Your Reference: MP 10_0160
Our Reference: OUT18/3910

Re: White Rock Wind Farm Project (MOD 6) - Modification Proposal

Thank you for the opportunity to provide advice on the above matter. This is a response from the NSW Department of Planning & Environment – Division of Resources & Geoscience, Geological Survey of New South Wales (GSNSW).

Figure 6.4 Location of proposed offset sites to meet offset requirements for Stage 2 impacts

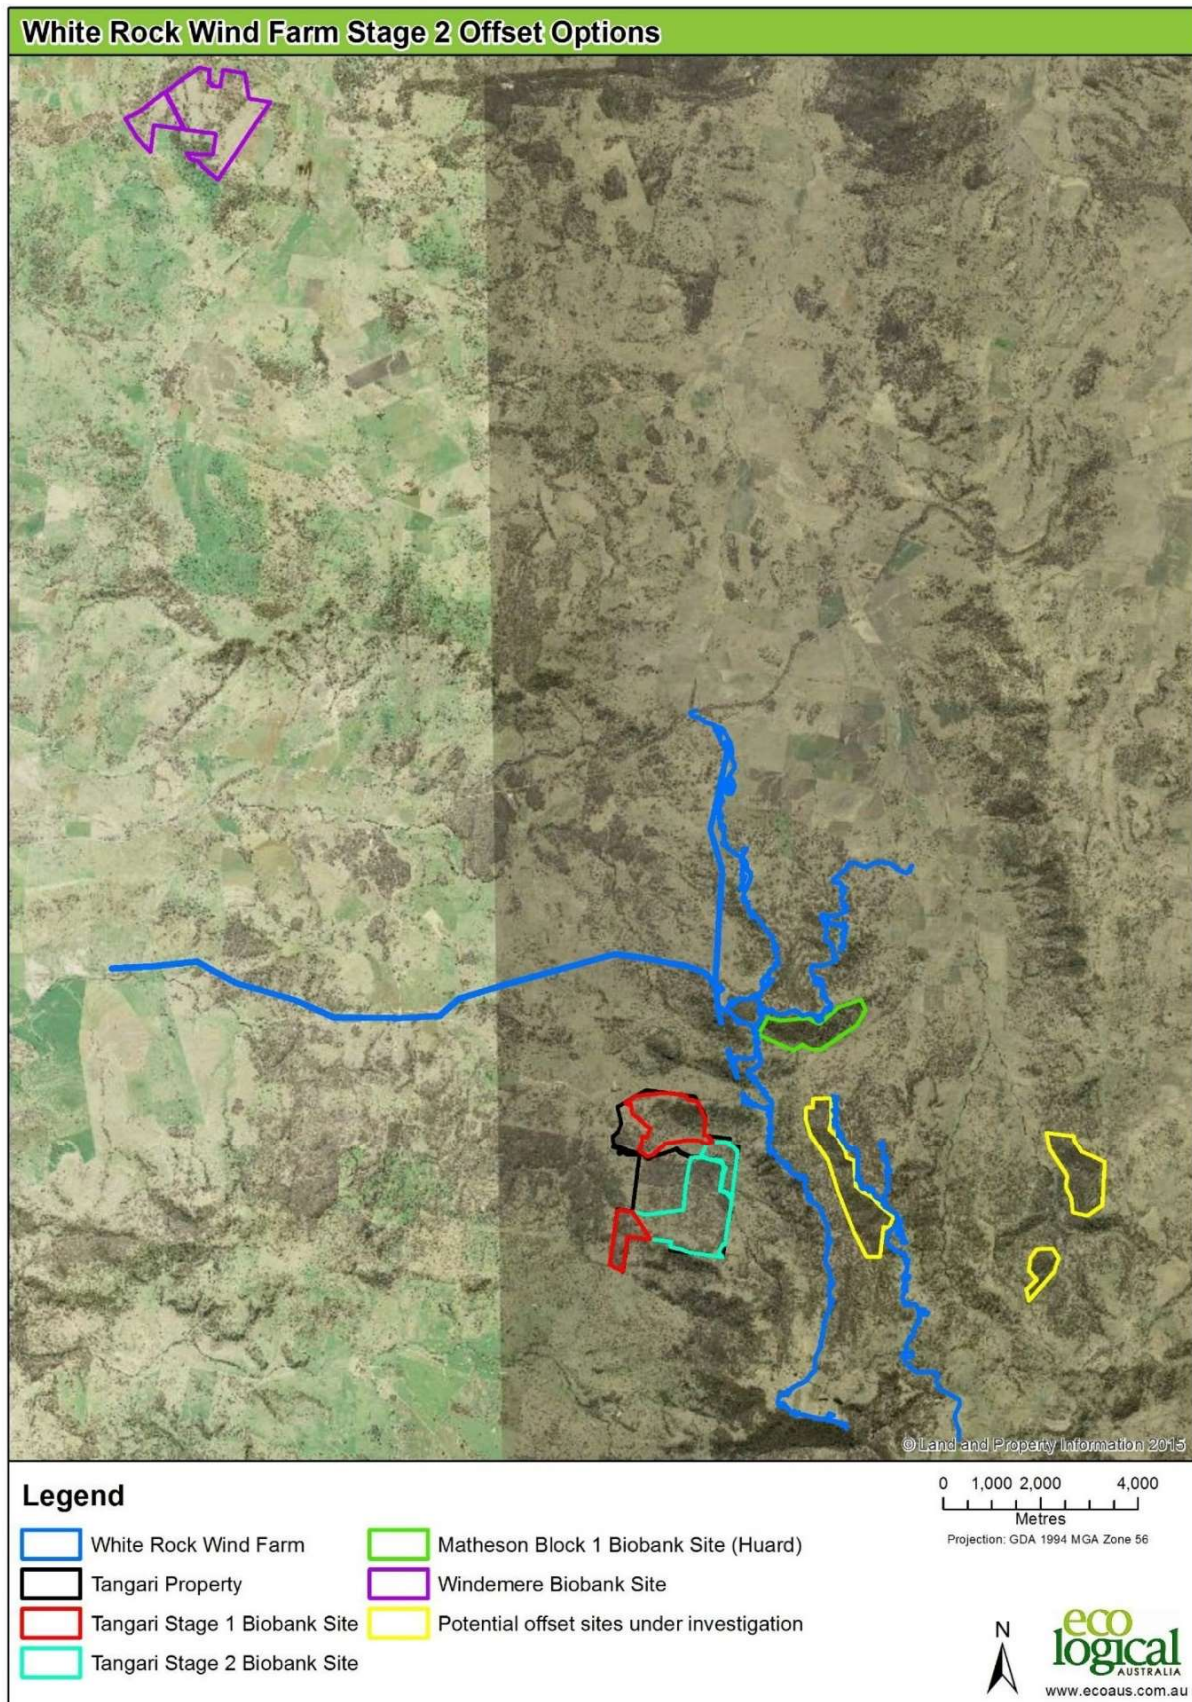
GSNSW notes that the proposed Windemere Biobank Site (as indicated within the White Rock Wind farm MOD 6 – EA Main Report - Figure 6.4) is located within the Exploration Licence Application (ELA) 5592 held by New England Blue Pty Ltd (Refer to Figure 1). GSNSW has concerns relating to the biobanking application area regarding potential resource sterilisation. This area is prospective for sapphires and the proposed biodiversity offset area may adversely affect explorers locating potential resources. GSNSW requests the title applicant be consulted in relation to the proposed biodiversity location with a record of consultation included in the EIS. GSNSW requests to be consulted in relation to the proposed location of any biodiversity offset areas or any supplementary biodiversity offset measures to ensure there is no consequent potential sterilisation of mineral or extractive (construction material) resources. The contact details for New England Blue Pty Ltd (that the GSNSW currently has on record) are as follows:

Similarly, GSNSW note that the proposed location for the Matheson Block 1 Biobank Site – Huard (Figure 1), located within Lot 1 DP 1061812, is adjacent to the approved extractive industry (quarry) referred to as the Hugans Pit (Reference: Glen Innes Severn Council July 2016, Development Approval GD:CA:GP for DA No.52.15-16 dated 22nd July 2016). The existing approval comprises 1.42 ha and consists of a “discrete area located on the western side of the White Rock Wind Farm access road” (Reference: pp 18 SOEE Hugans Pit Mod). GSNSW requests the proponent consult with Glenn Innes Severn Council (as the Consent Authority for this extractive industry) regarding the potential for resource sterilisation and/or discussion around the potential for a reduced biodiversity offset area, resulting from future quarrying activities, with a record of consultation included in the EIS.
